HS3 Phase 1 (also described by the developers as HS3 Phase 2), now the subject of planning application 2022/91735

I have considered the planning application made for site HS3 Phase 1 now 2022/91735 and wish to make the following comments:

Appendix G HS2 & HS3 Joint Masterplan and Phasing Plan

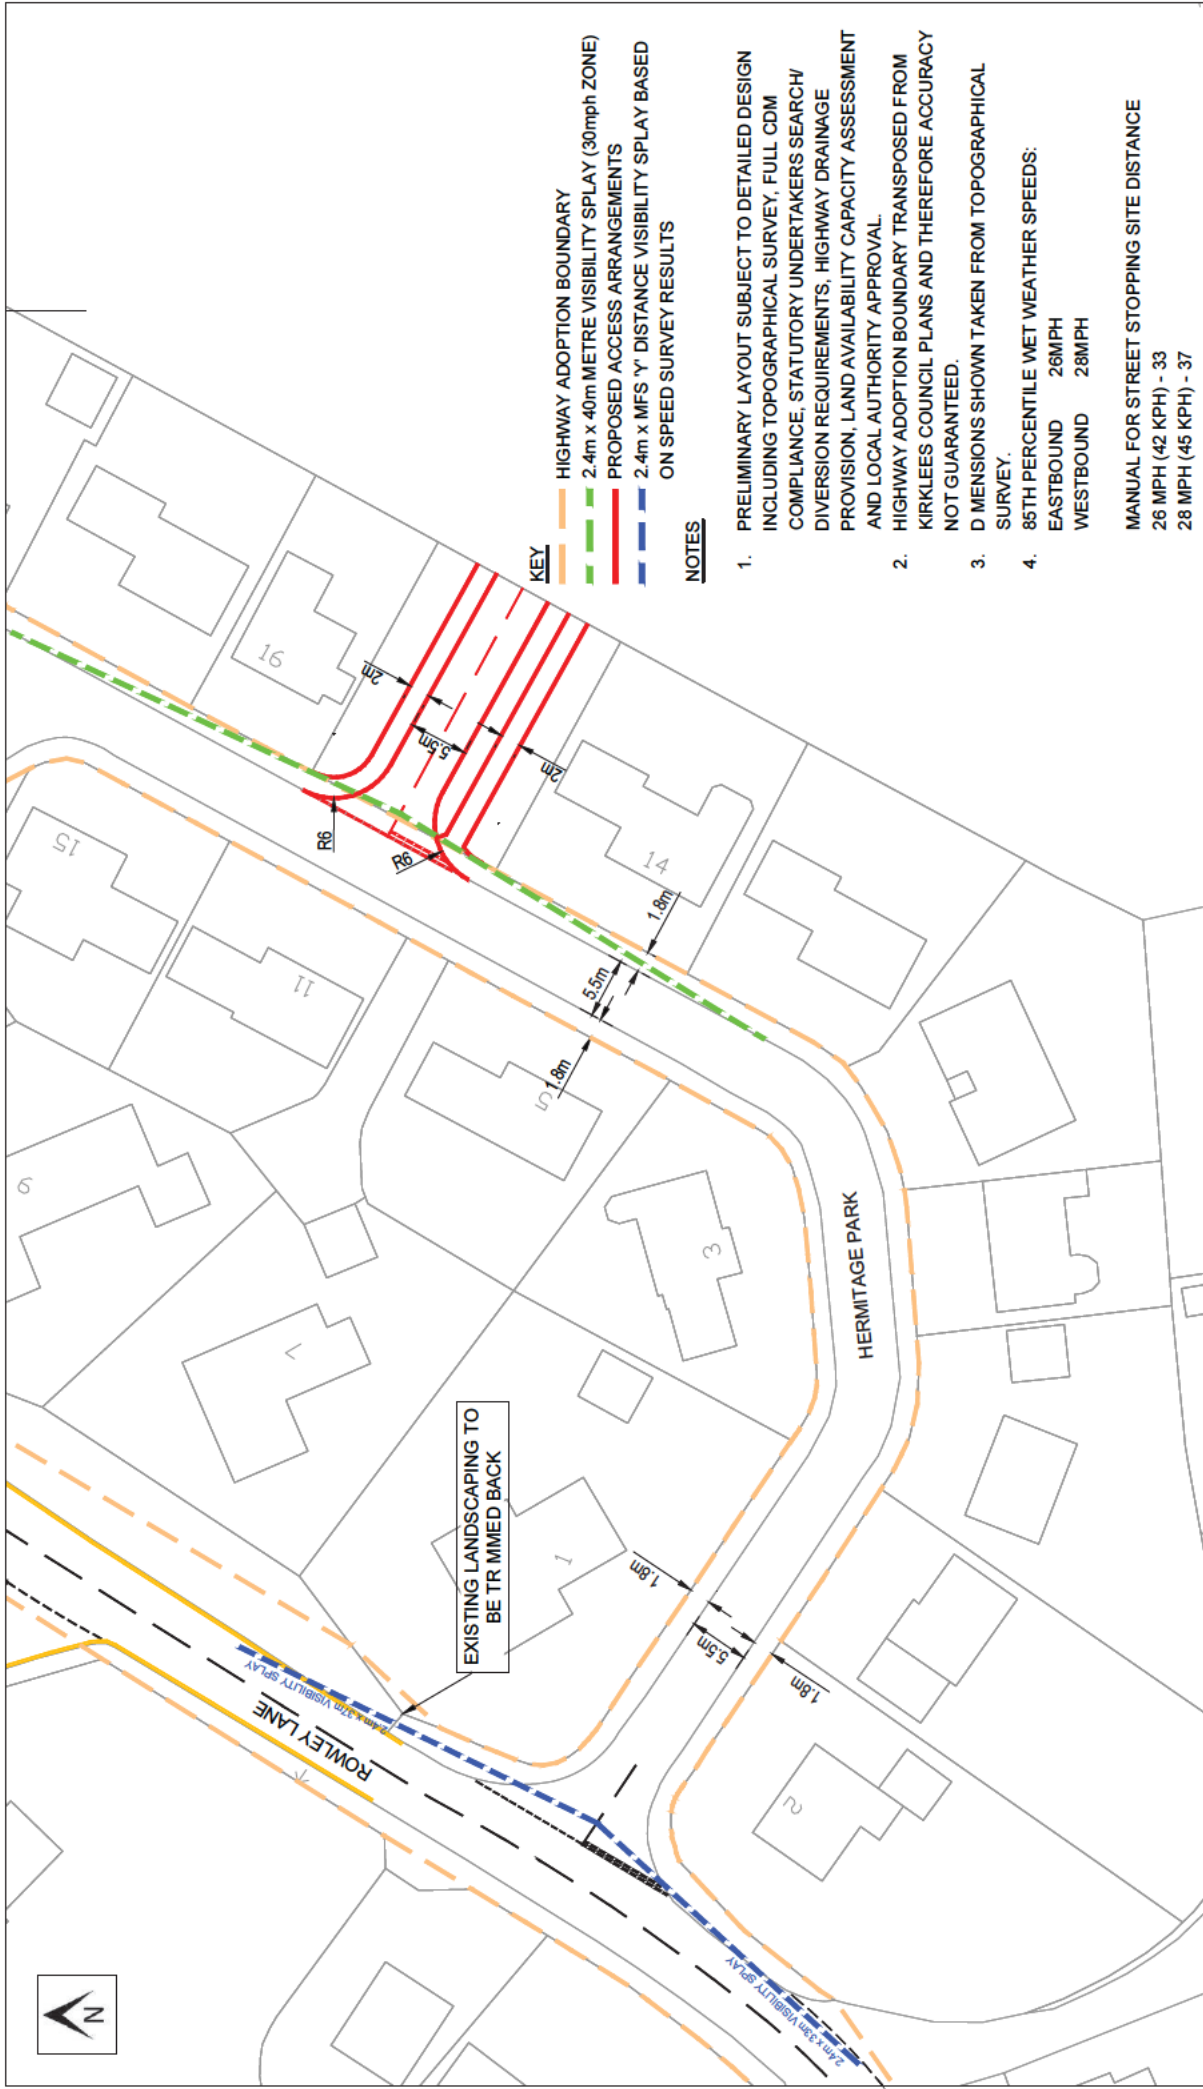
- 1- The joint master plan submitted in support of this application seems to be the same as the one submitted for HS2 Phase 1 now known as 2020/92307. This does not comply with PLP 5 as required by the main modifications mm 43 and mm 46.
- A) The masterplan does not address the creation of a strong sense of place, nor describe how it will add or be beneficial to Lepton's residents or quality of place.

Additionally in describing its plans to create a sense of place the Master plan refers to a sequence of linked spaces which gradually step up the sloping site. It is not clear how this will be achieved though given the somewhat haphazard approach to the developments, based purely it seems on cost. There are therefore no assurances this sense of place as described will ever happen. There is no provision within the joint masterplan for a community centre or recreational activities such as tennis courts. I understand the nearest ones are at a private club on Longley Rd. Additionally a community centre would be of huge benefit to the community of Lepton and Fenay Bridge. There is no green space set aside for community allotments such spaces are needed for the future sustainability of communities and while I note a community allotment on Highgate Crescent is mentioned, I was not aware of it nor have I ever seen it. I do not see evidence of any sense of place.

I understand that pre-app guidance from the Council underlined any application must be supported by a Masterplan that demonstrates the potential and cumulative impact of the allocated housing developments at HS2 and HS3 as well as its deliverability. I have not seen evidence of this in relation to:

Appendix L Drawing 13015/IN/07 – Rowley Lane/Hermitage Park Junction Dimensions

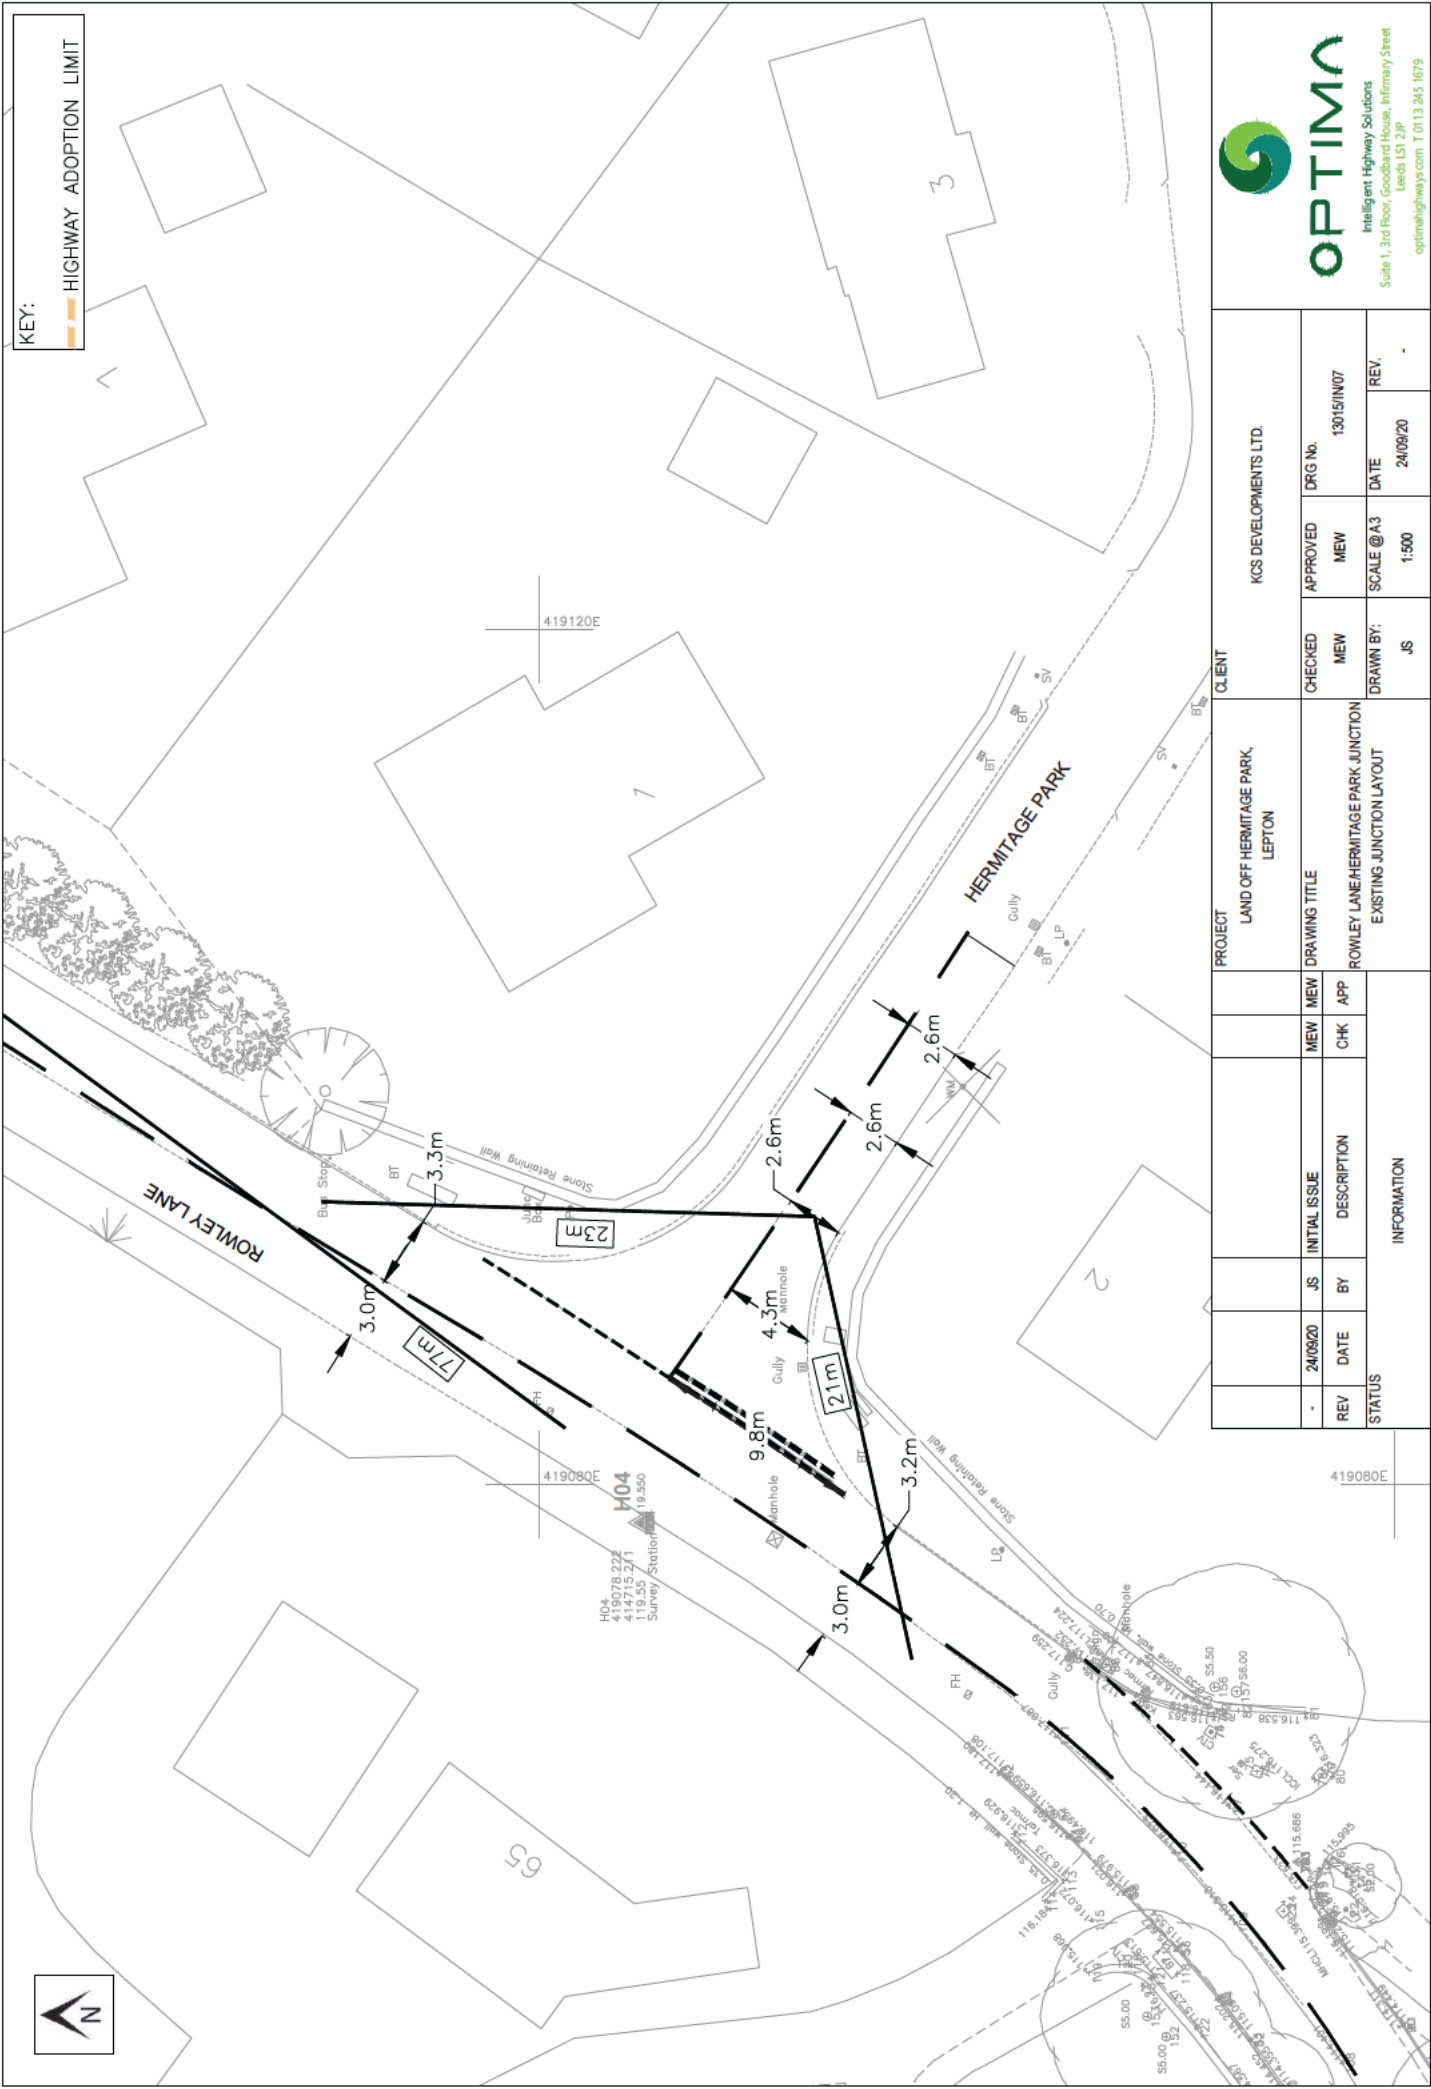
I would like to know how this joint plan is deliverable when there are so many unknowns and ambiguity such as there is no assurance a roundabout or the road infrastructure that is needed will ever be built? How will Hermitage Park accommodate 80 houses or even 45 with its junction with Rowley Lane so dangerous and narrow?

I do not see how Hermitage Park can feasibly serve a further 45/50 houses. I suspect most of the house owners in Hermitage Park have two cars. They will also have visitors, deliveries and service vehicles using the road. Additionally many of the houses on Hermitage Park do not have big front gardens so they will be quite badly impacted by the increase in traffic noise and people all travelling past their homes. I note some of them will also be impacted at the rear too by the new houses.

It simply cannot be right to let the developers proceed with their plans which do not adhere to the main modifications mm 43 and mm 46 made by the Inspector to make the Local Plan sound. Residents of Hermitage Park require assurances. The Hermitage Park junction with Rowley Lane is just below a bend and chaos reigns at school pick up and drop off times. Additionally parents park their cars up Hermitage Park at school opening and closing times, so the Road is even busier and difficult to travel up and down. This seems to have been overlooked.
